Response to Comments: 65 Munjoy Street Condominium Development

Date: January 27, 2016

Comments Submitted by: Nell Donaldson, Planning Division on 2015-12-31

**RECORDING PLAT**  
65 MUNJOY STREET  
65 MUNJOY STREET, PORTLAND, MAINE  
MADE FOR  
ANEW DEVELOPMENT  
17 CHESTNUT STREET, PORTLAND, MAINE  
OWNER OF RECORD: CITY OF PORTLAND

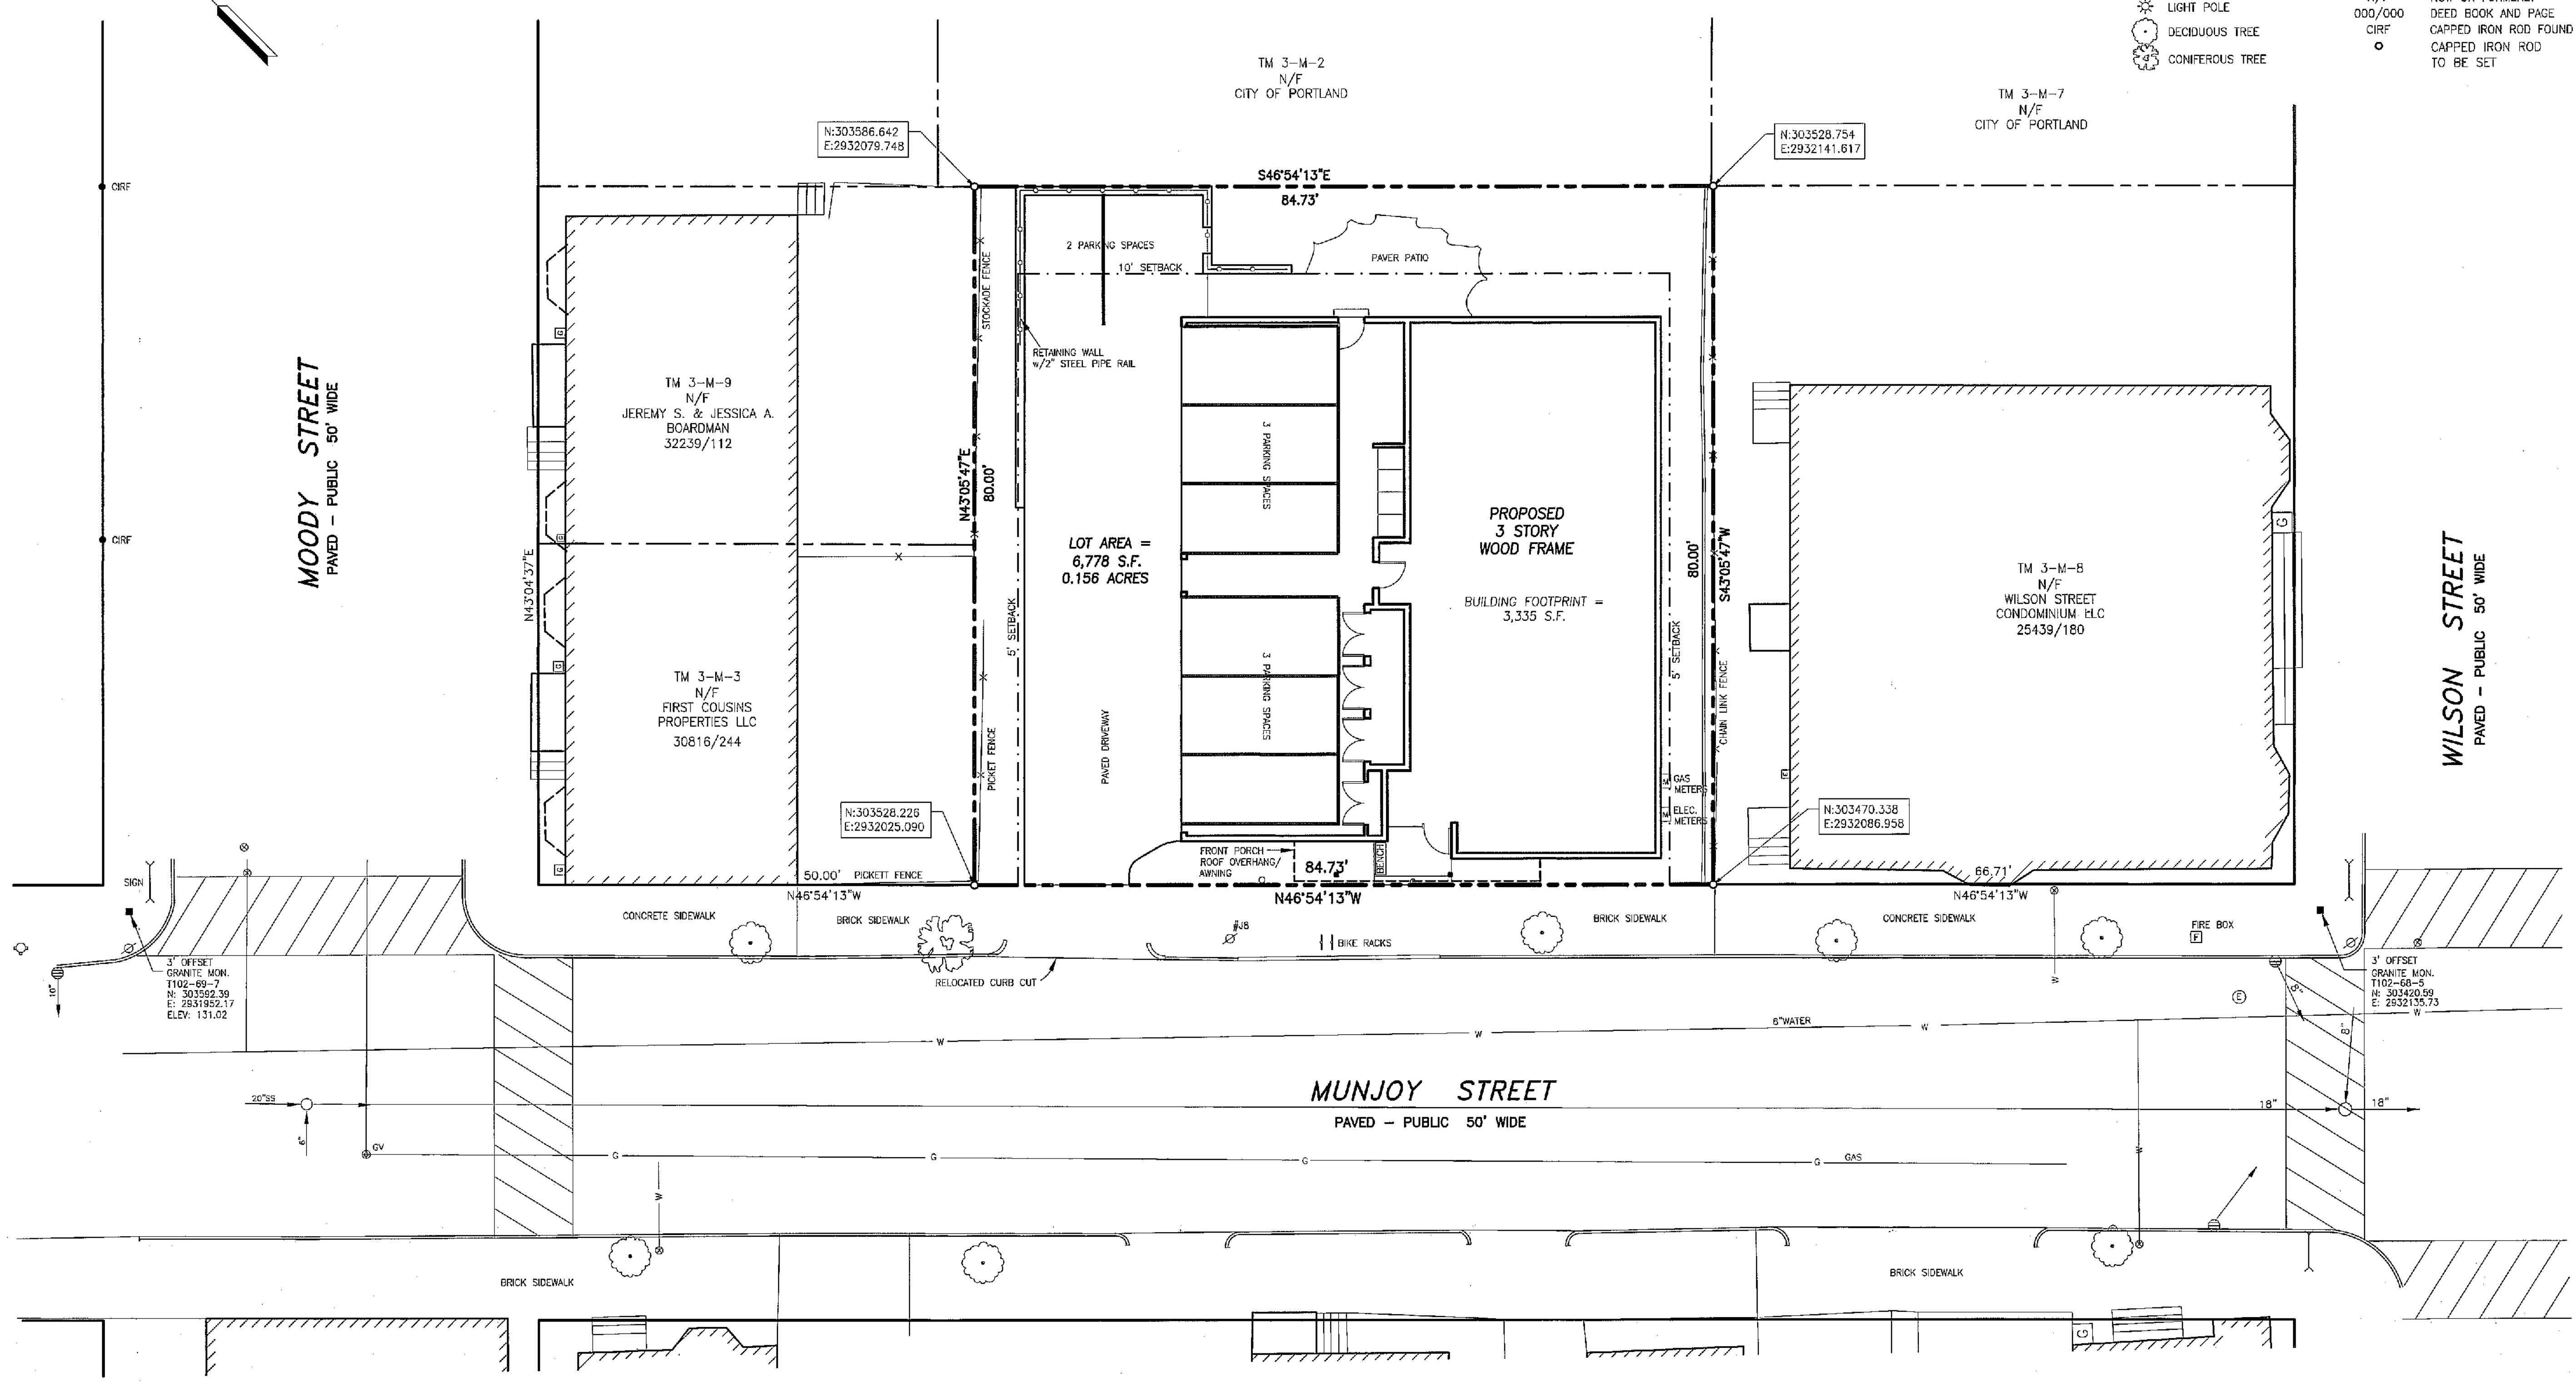
1. The Subdivision Plat dated 12 10 2015 looks good and the bearings and distances match the metes and bounds description I prepared on October 9 2015.

Response: No response necessary.

**CONCEPT DOCUMENTS ELEVATIONS**

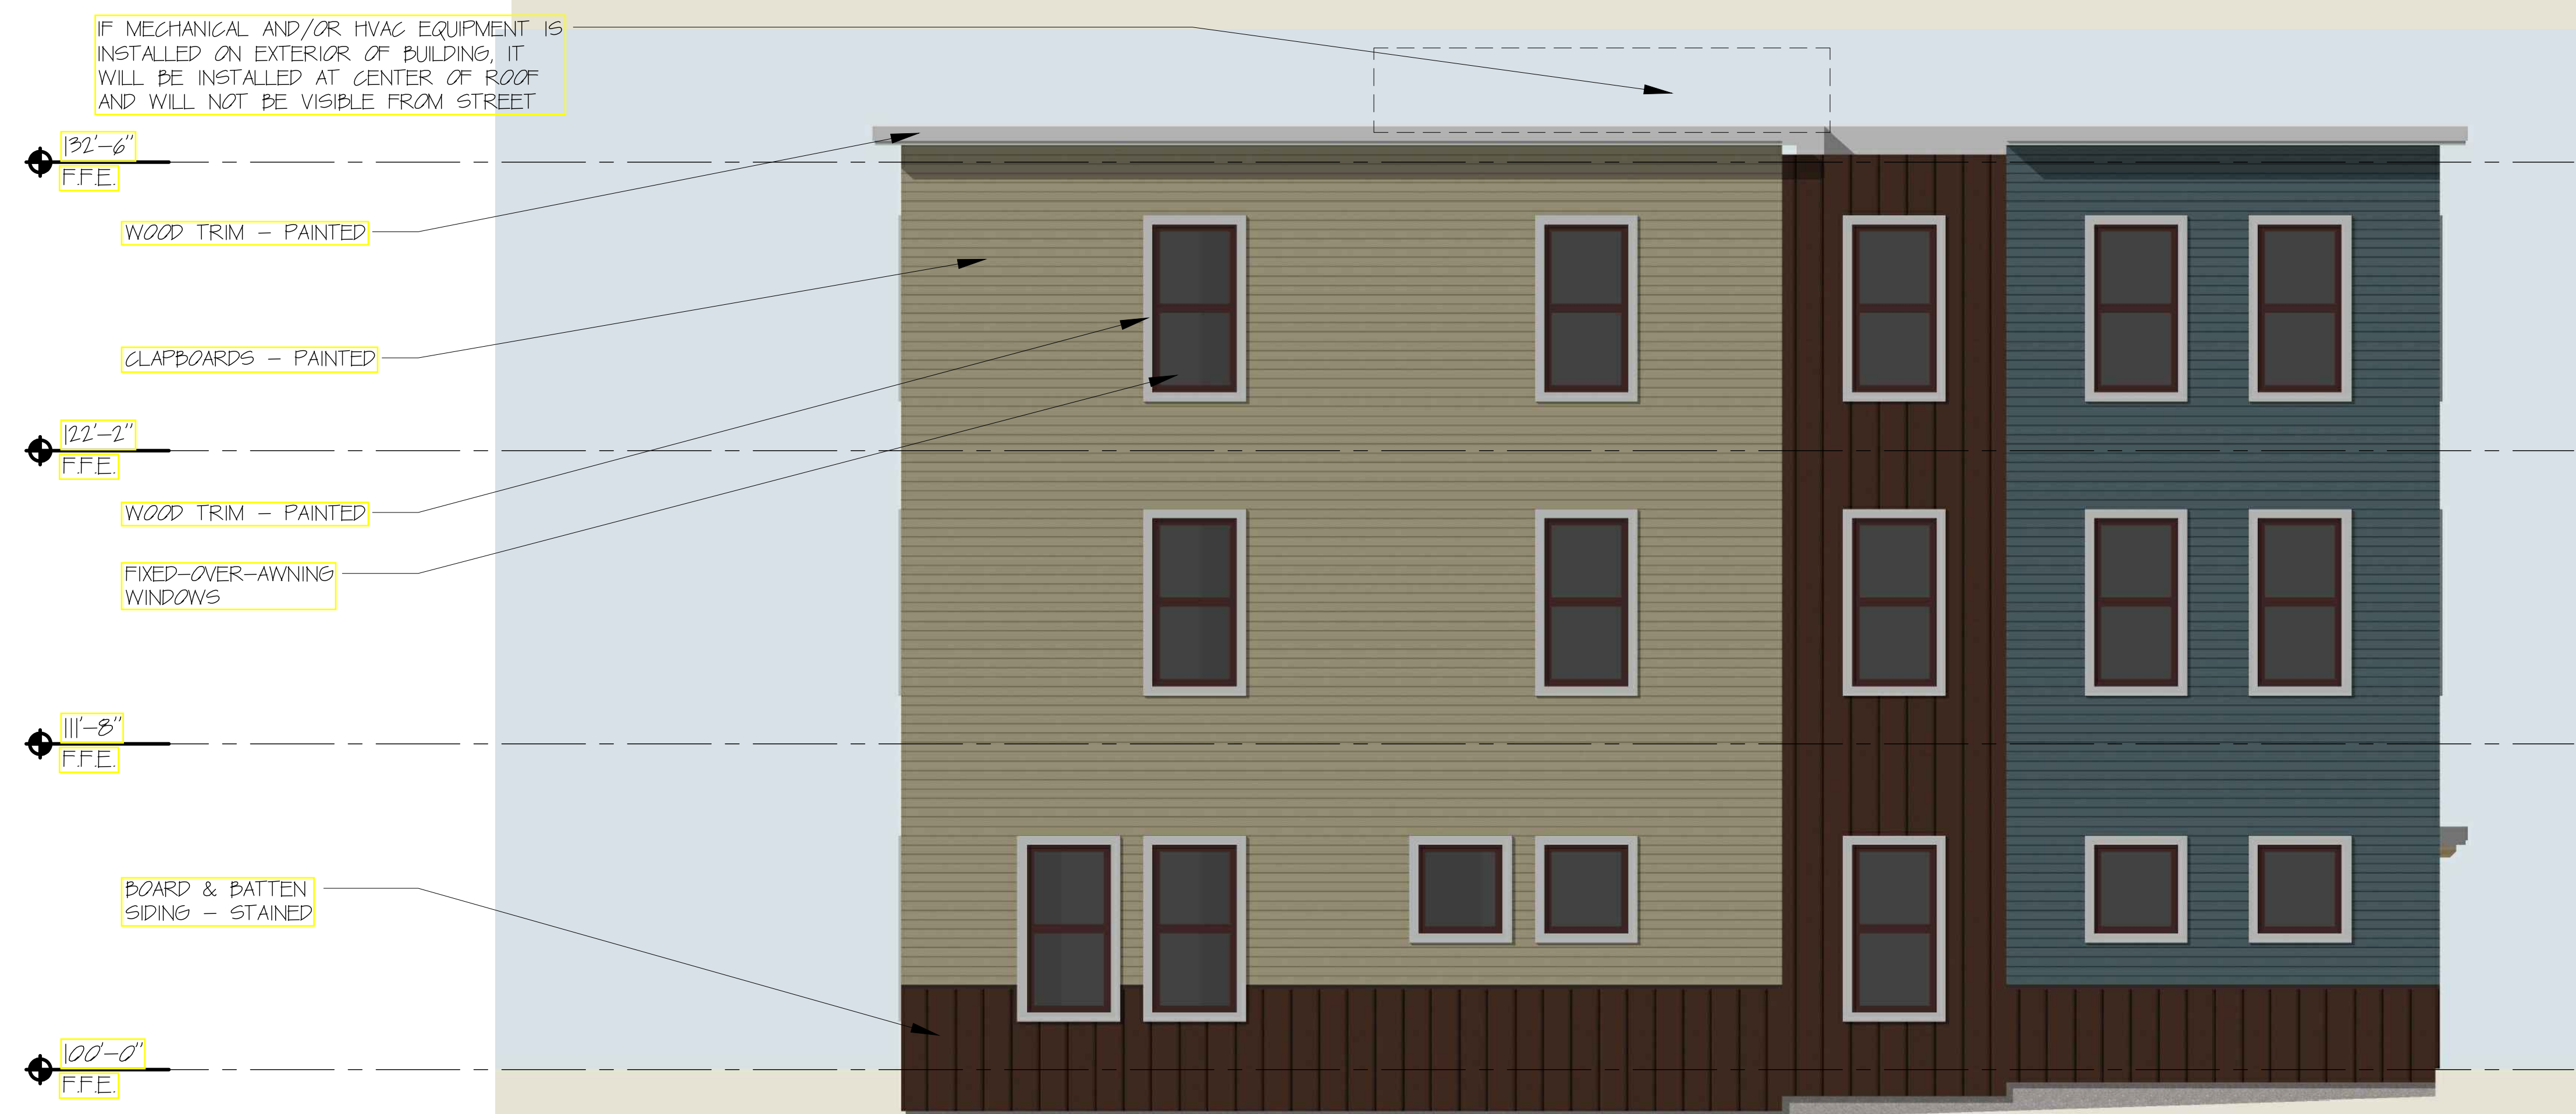
11. Zoning

Distance to Property Show full height on elevations (i.e. include distance from ground to FFE)

Response: The distance from ground to FFE has been included in the revised architectural drawings.

Sheet No:
C1

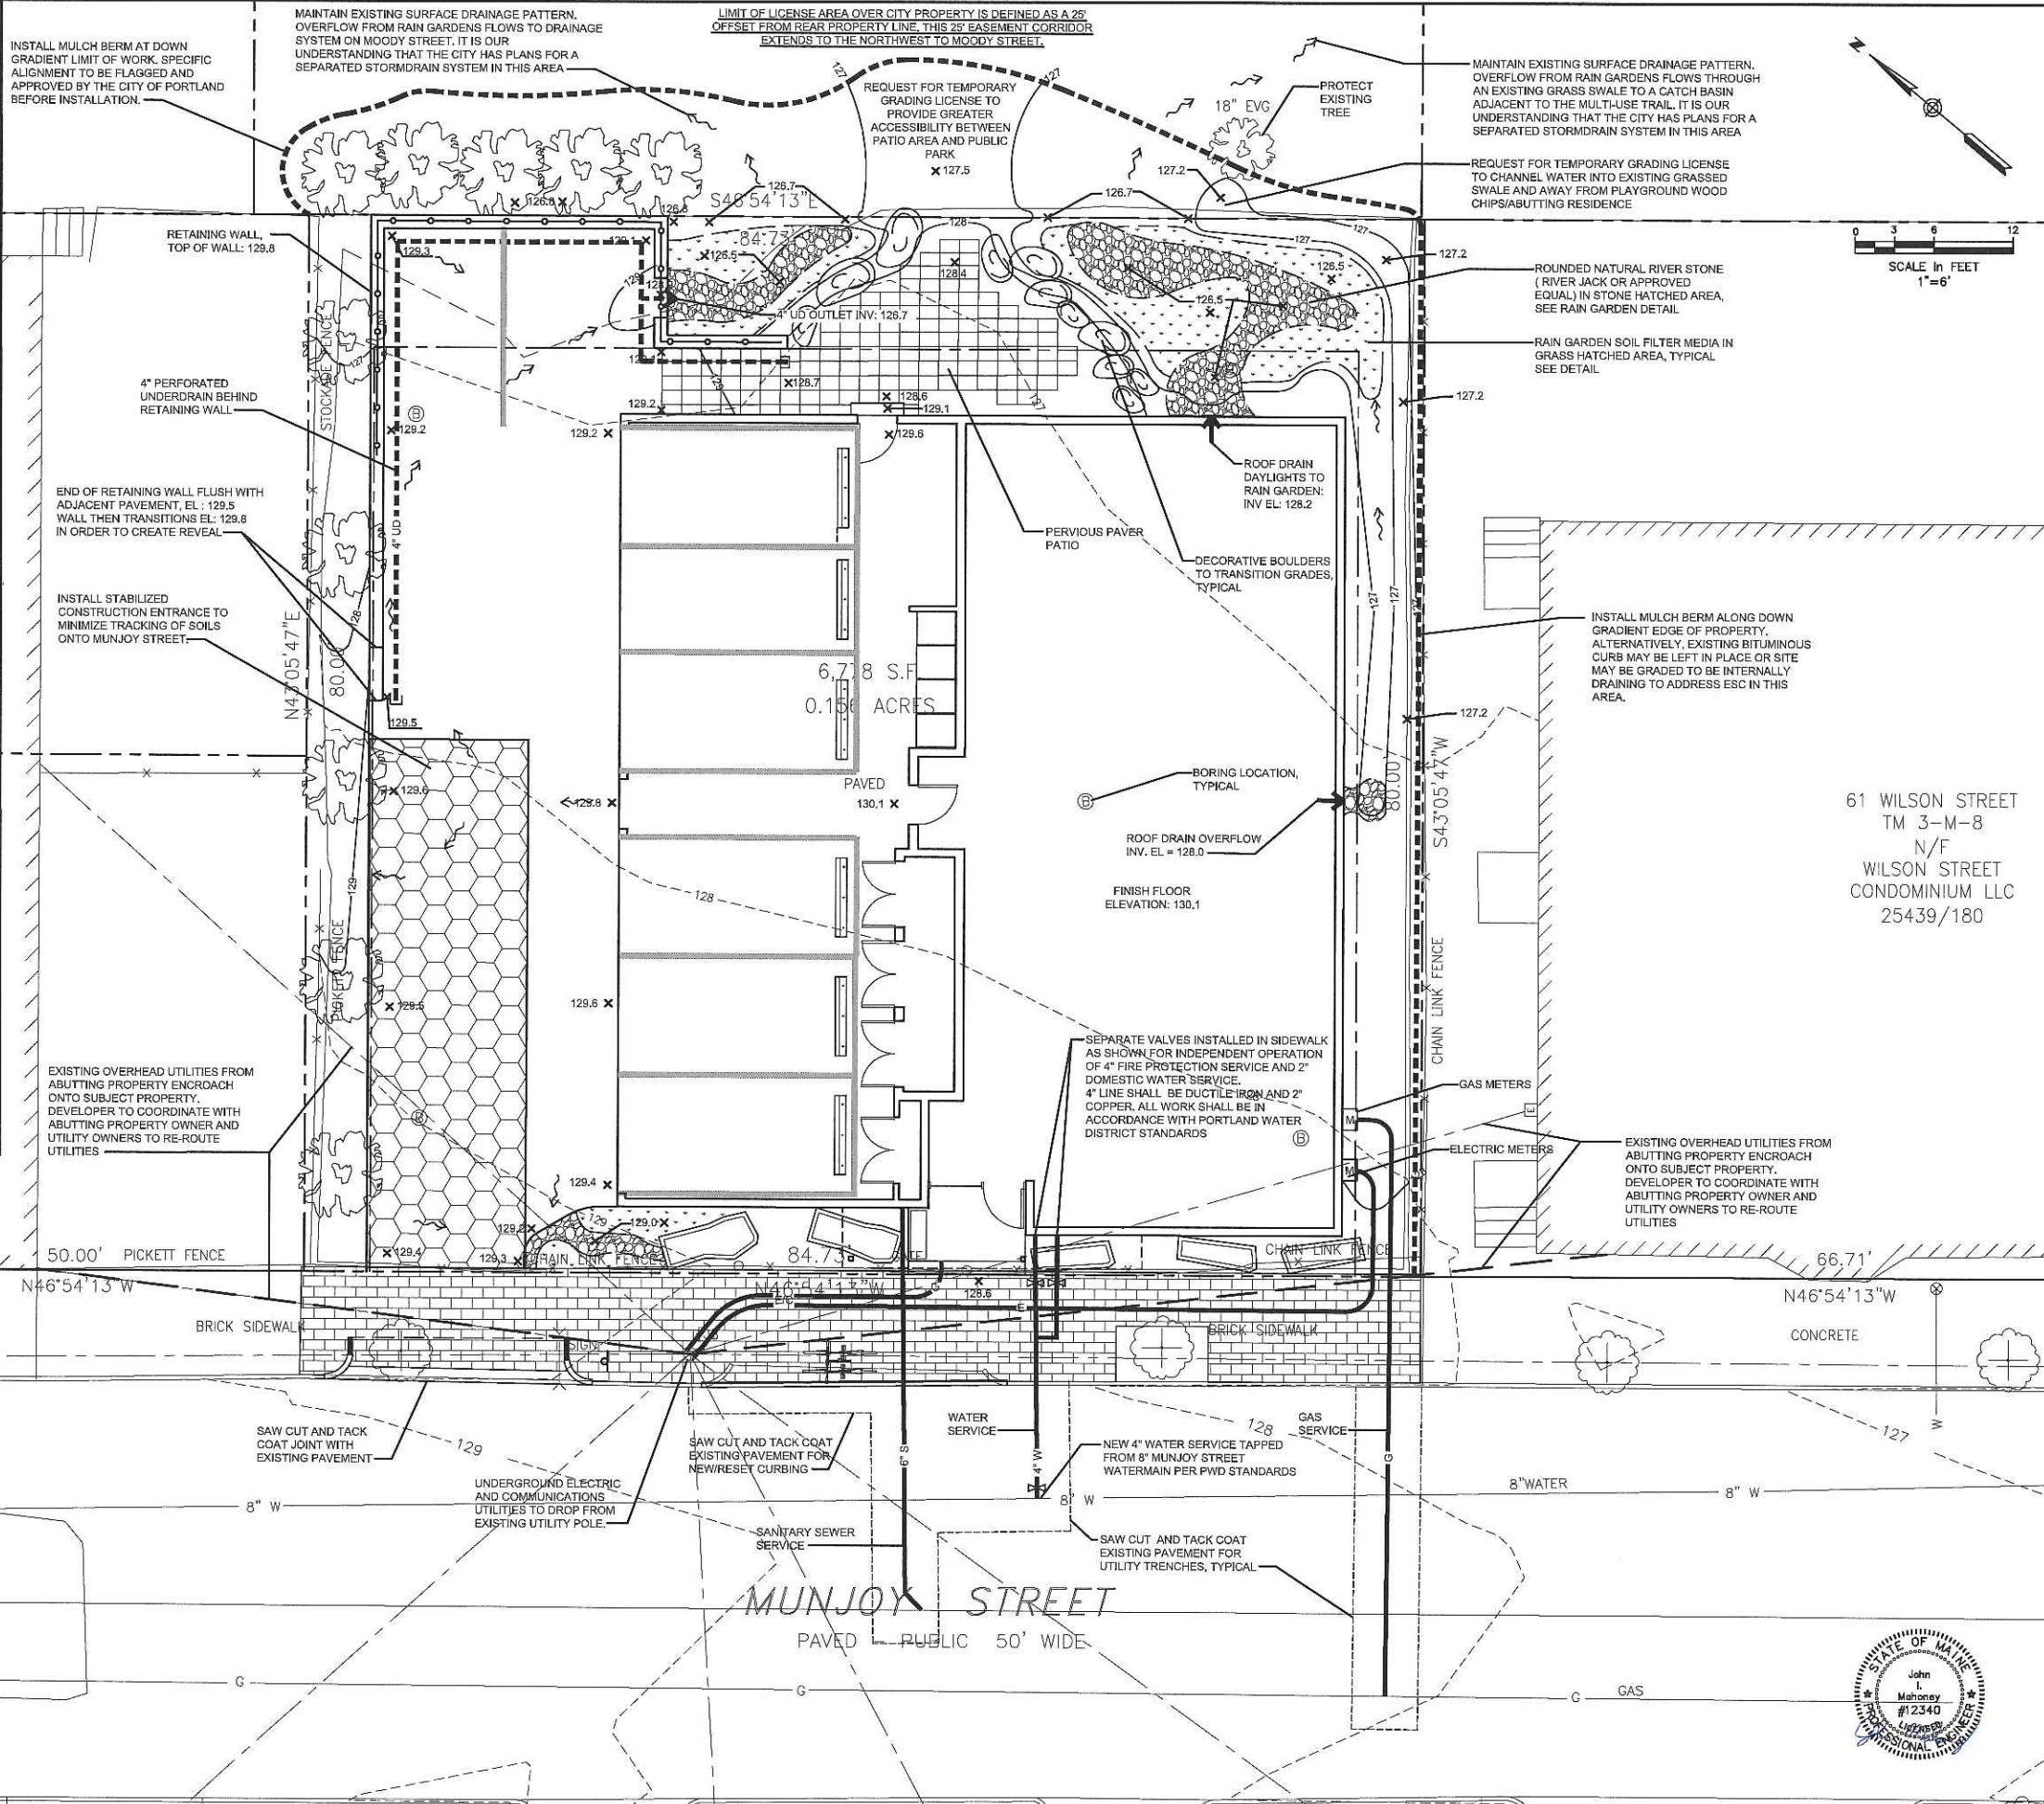
3. The site plan locates the narrowest parking space in a location where the building column will constrain vehicle maneuvers. I would suggest that the narrow space be located without building column interference.

Response: The narrowest parking stall has been relocated as shown on Sheet C1.
